# BCA Assessment Report

St Aloysius College, Rozelle

<b>Project:</b>	St Aloysius College, Rozelle
<b>Reference No:</b>	113752-BCA-r1
<b>Date:</b>	26 October 2021
<b>Client:</b>	PMDL Architecture & Design Pty Ltd
<b>Client Contact:</b>	Andrew Pender
<b>Email:</b>	<a href="mailto:apender@pmdl.com.au">apender@pmdl.com.au</a>
<b>BCA Logic Contact:</b>	Ben Long
<b>Direct:</b>	8484 4009
<b>Email:</b>	<a href="mailto:blong@bcalogic.com.au">blong@bcalogic.com.au</a>

This document provides an assessment of the architectural design drawings for the proposed alteration to the existing development at St Aloysius College, Rozelle, against the Deemed-to-Satisfy provisions of the Building Code of Australia (BCA) 2019, Volume 1 Amendment 1.

48 Victoria Rd-Proposed Plan L1 St Aloysius College-Rozelle Campus

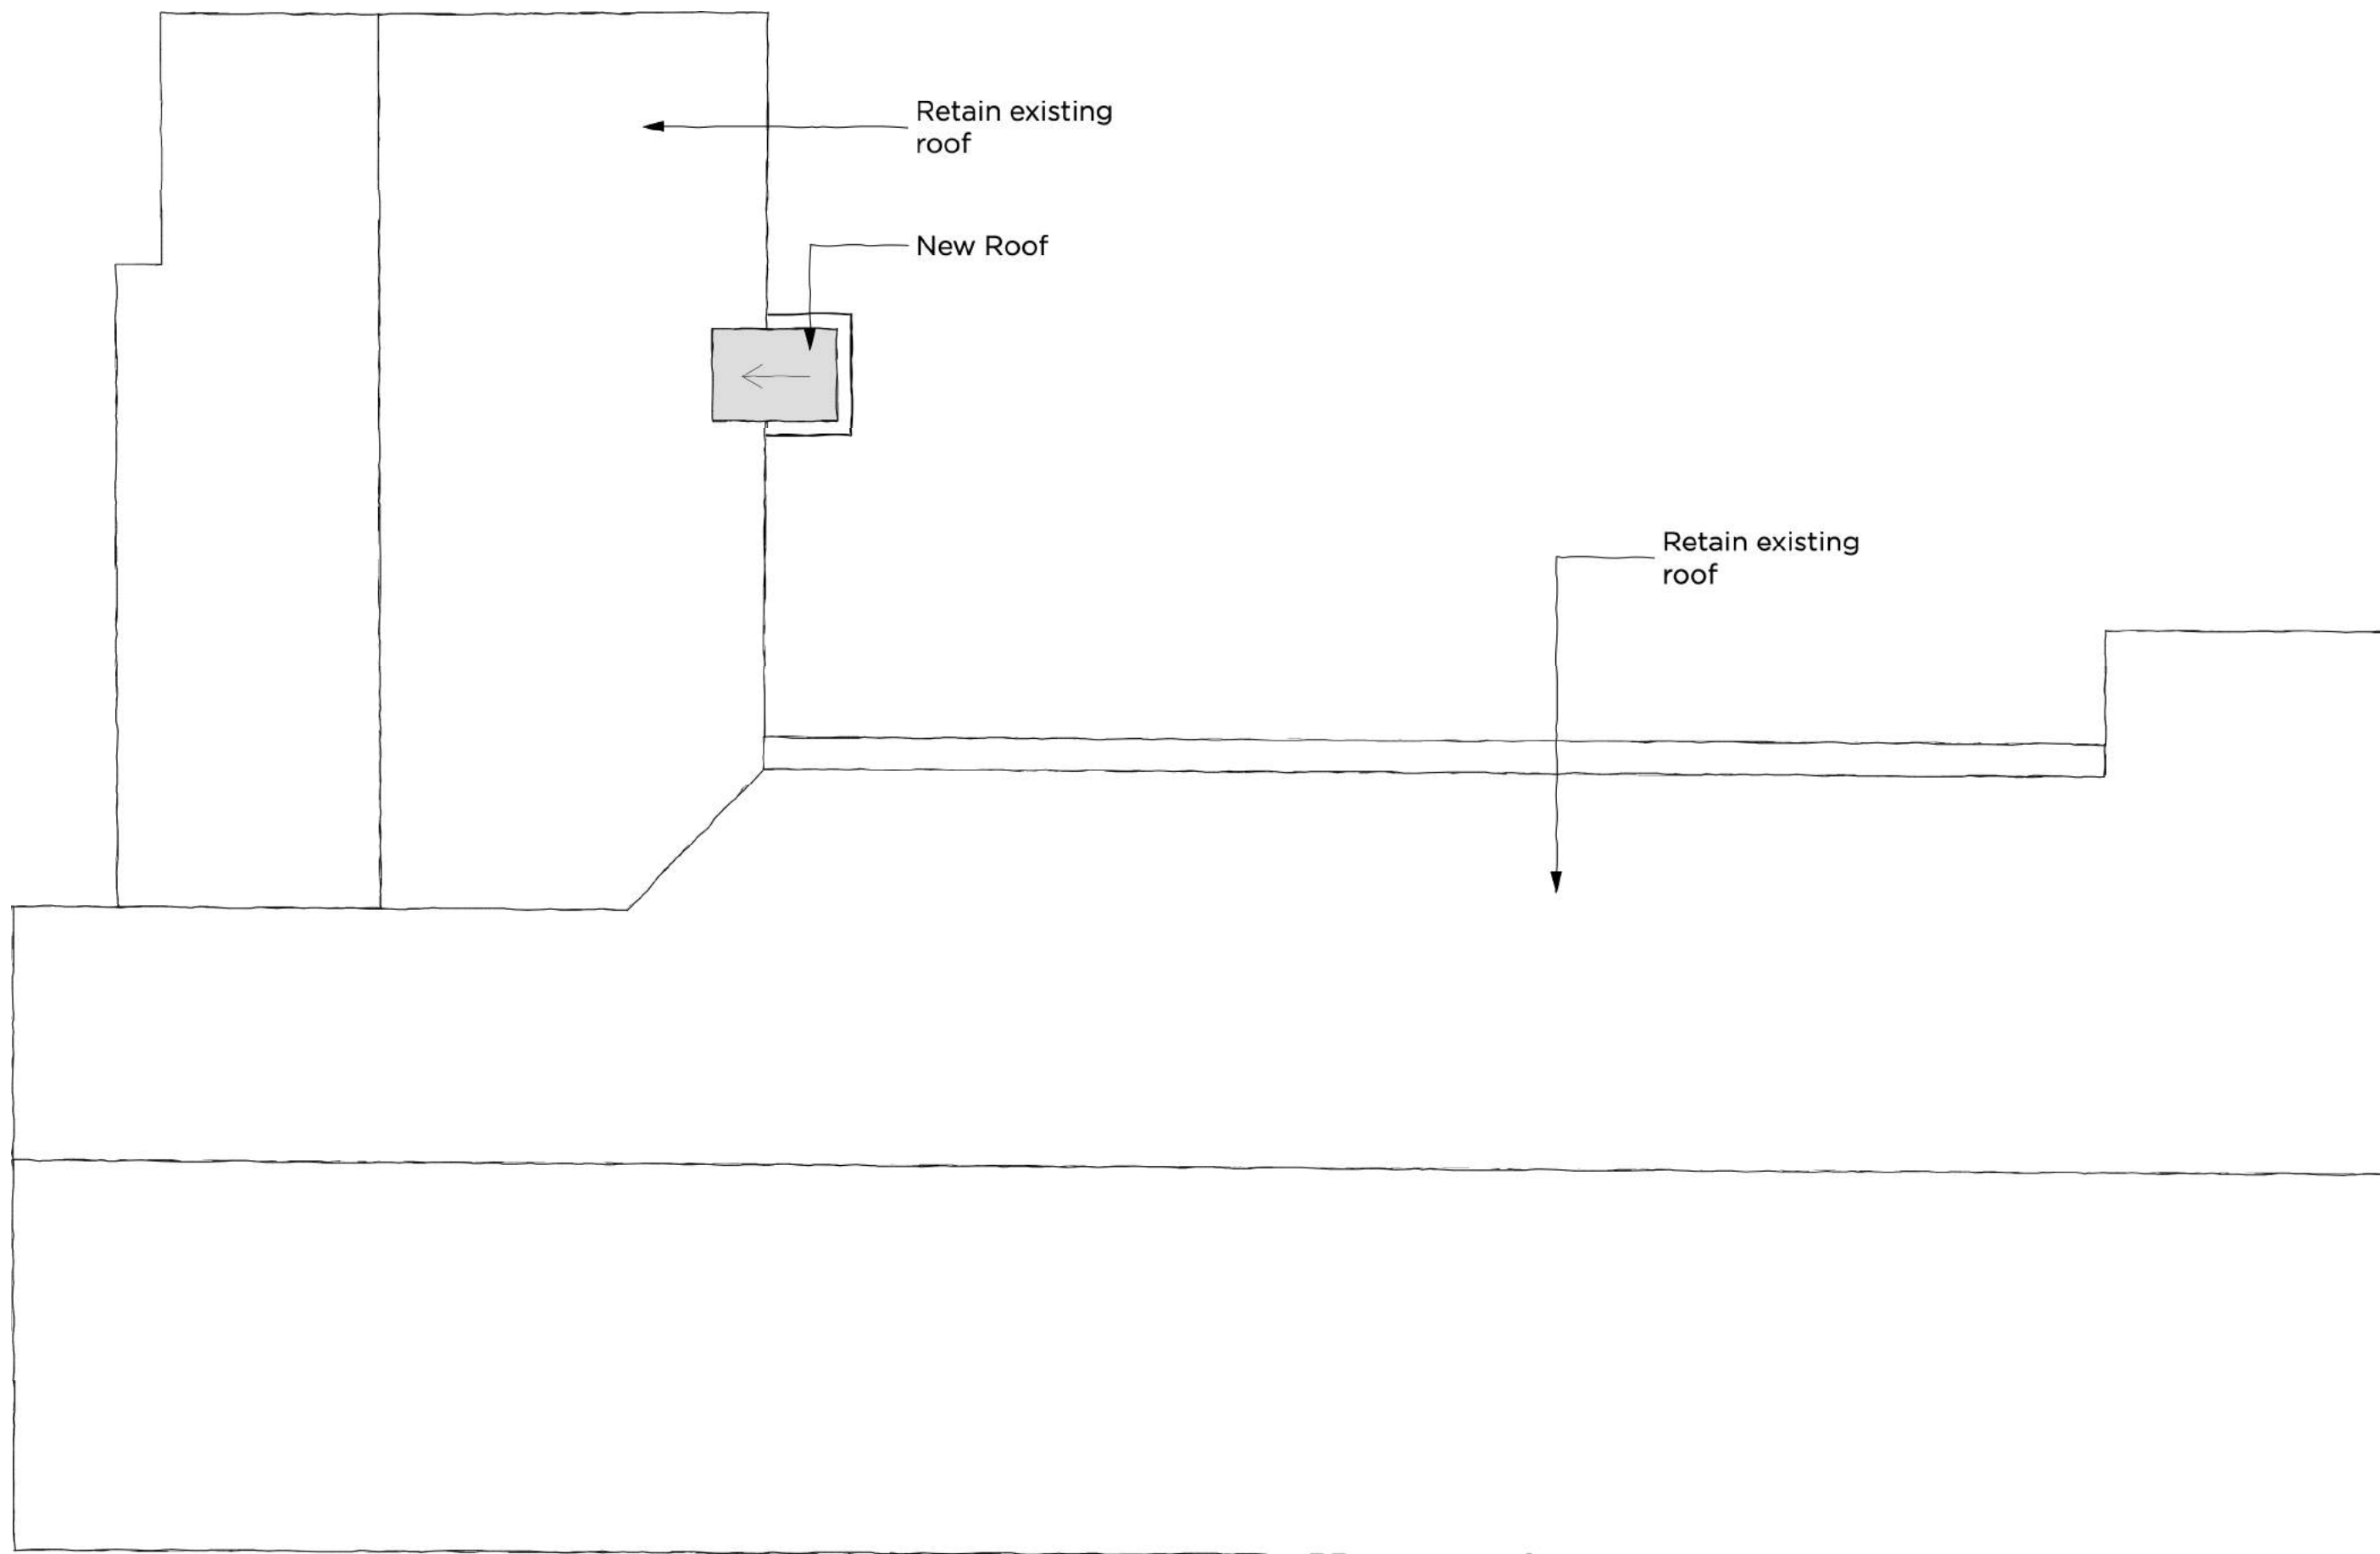
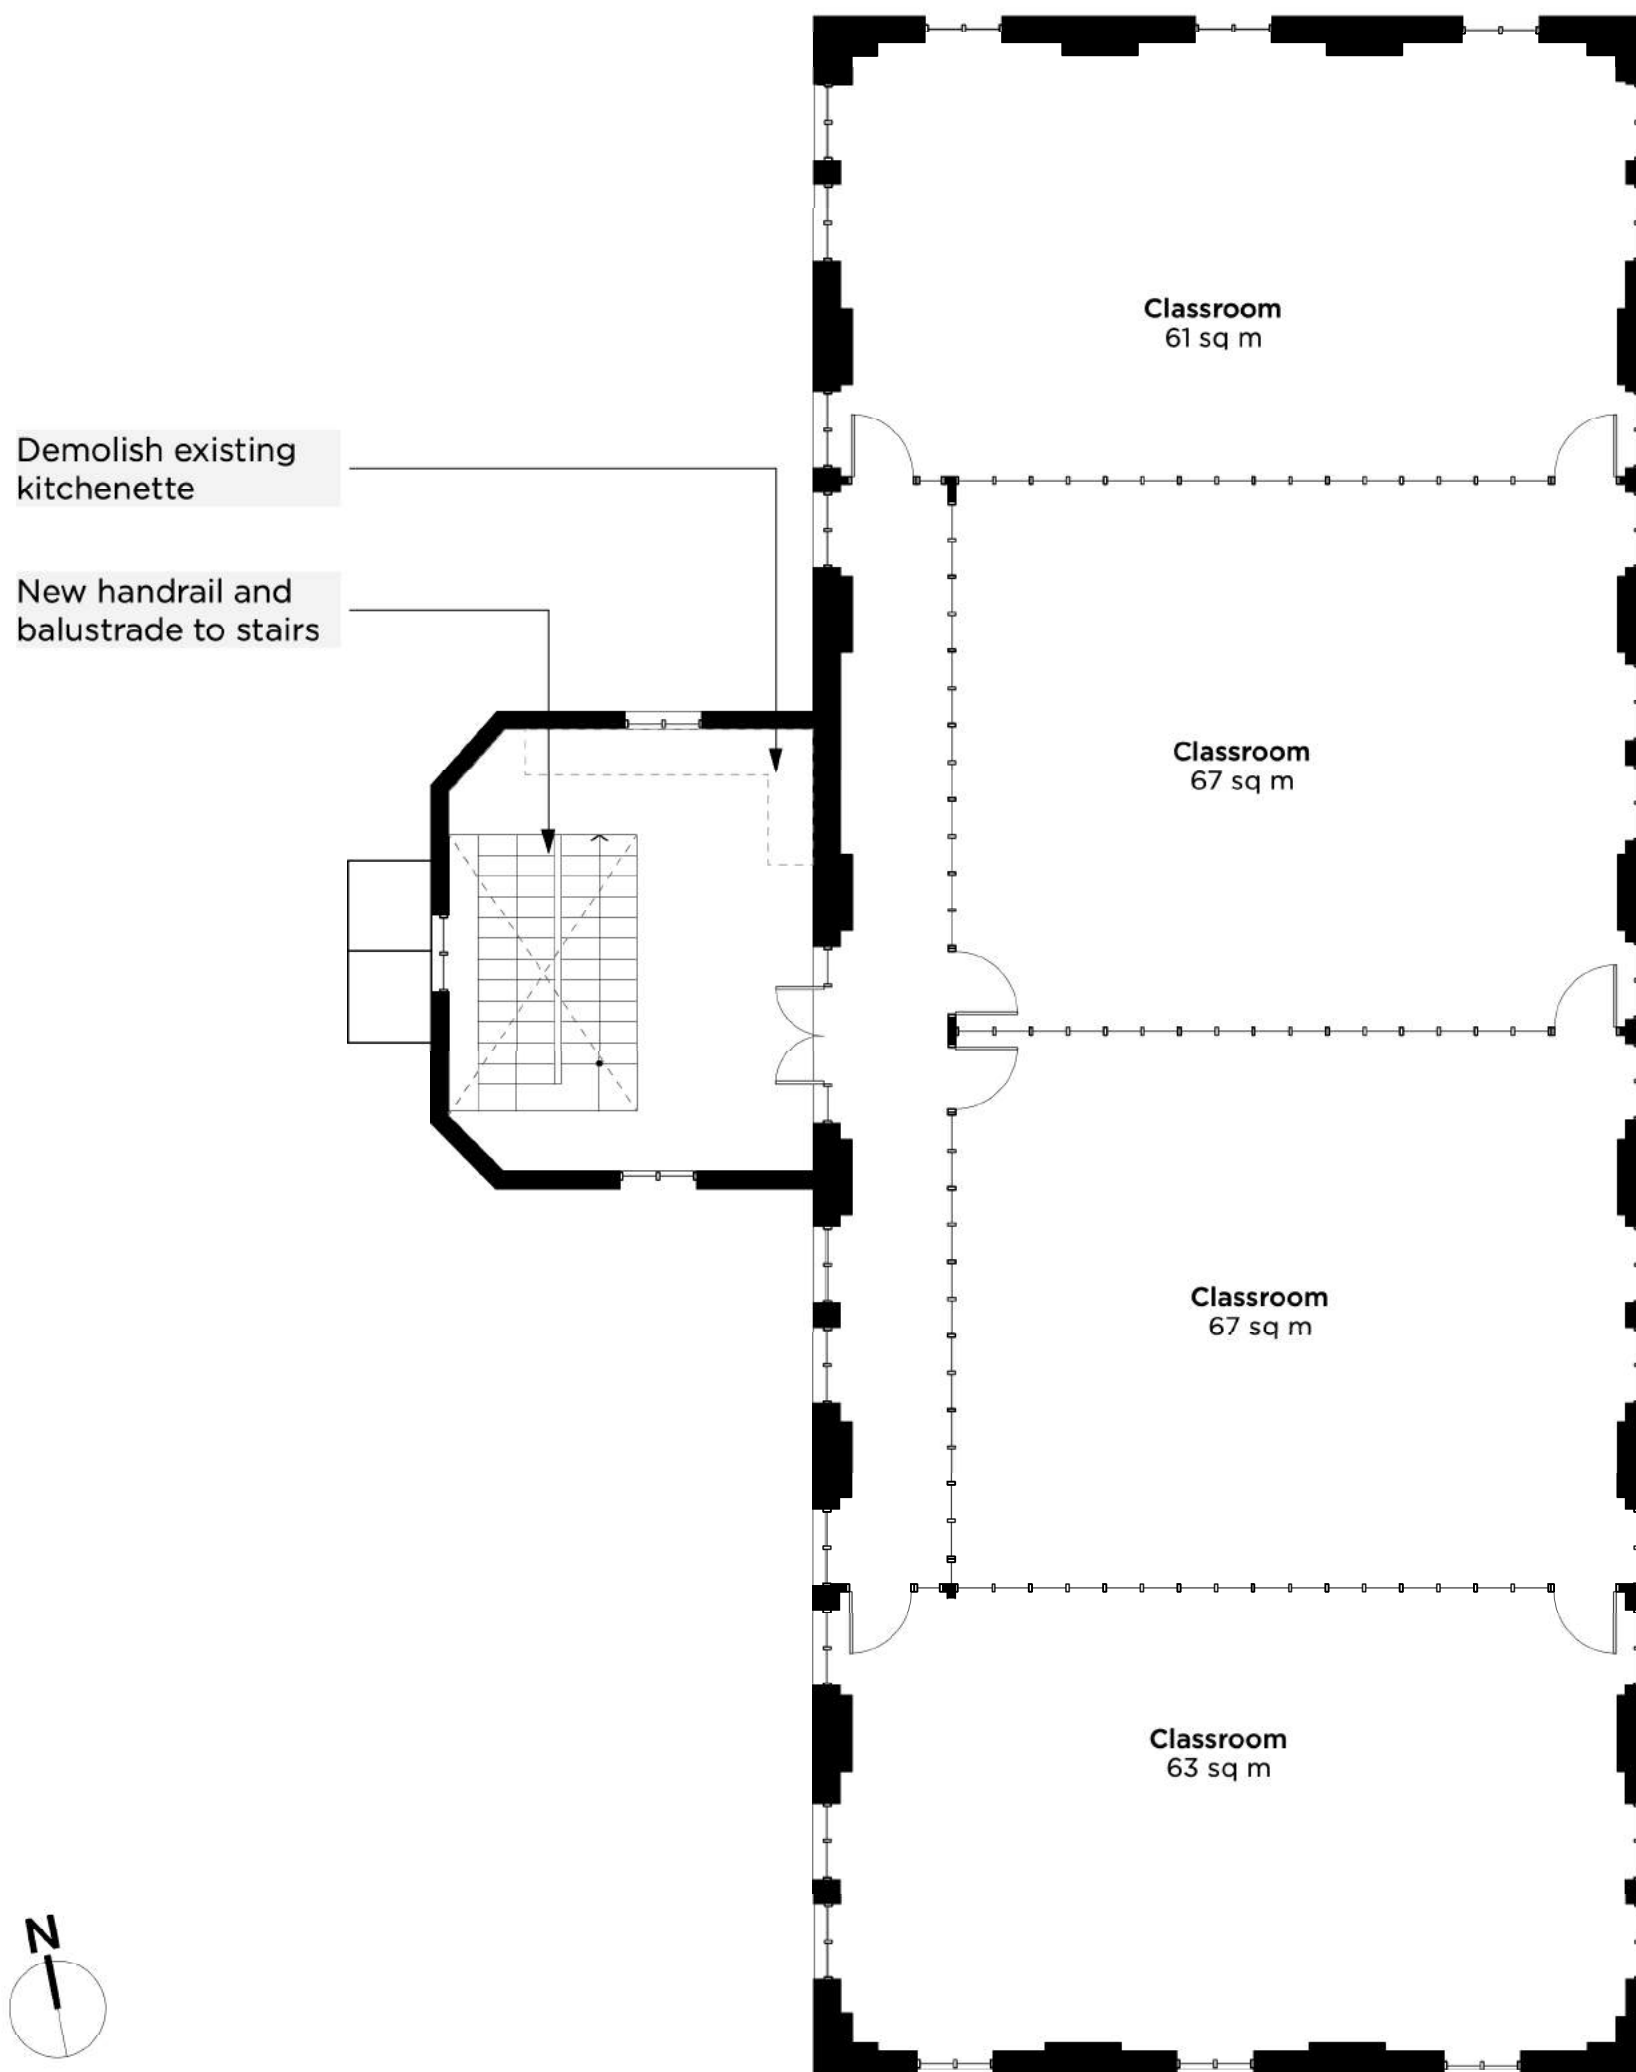
Furthermore, at the top of the western stair it is noted that there is an electrical board that will reduce the clear width to less than 1000mm. It would be required that this board is relocated as part of the new works to ensure that it does not impact on the egress widths.

Additionally, with the required works to the handrails under Clauses D2.17 and D3.3 it is considered that there will be a point on the western stair where the clearance between the handrails will be less than 1000mm and may need to be addressed via a Performance Solution – Refer to separate Access Report for more details.

Each of the non-fire isolated stairways are found to have an existing cupboard provided underneath that would not maintain the required FRL in accordance with this Clause.

It would be required that these enclosures are upgraded in accordance with this Clause to be at least 60/60/60 and contain a -/60/30 self closing fire door.

There are no nosing strips which have been provided to the existing stairways and therefore as part of the new works these shall be installed to each of the goings in accordance with this Clause.

It is noted that there existing barriers provided to the landing of the stairways are less than 1000mm and would not comply with this Clause. Additionally, the gaps provided within the barriers to the handrails would exceed 125mm and would not comply.

The barriers throughout will need to be replaced to ensure compliance is maintained in accordance with this Clause.

It is noted that there existing handrails provided to the landing of the stairways are less than 865mm and would not comply with this Clause. The handrails throughout will need to be replaced to ensure compliance is maintained in accordance with this Clause.

Furthermore, it is noted that the existing stair configurations did not provide an offset riser and therefore it would not be possible to maintain a consistent height throughout in accordance with Clause 12 of AS1428.1-2009. It would be possible to seek a Performance Solution to omit this requirement.
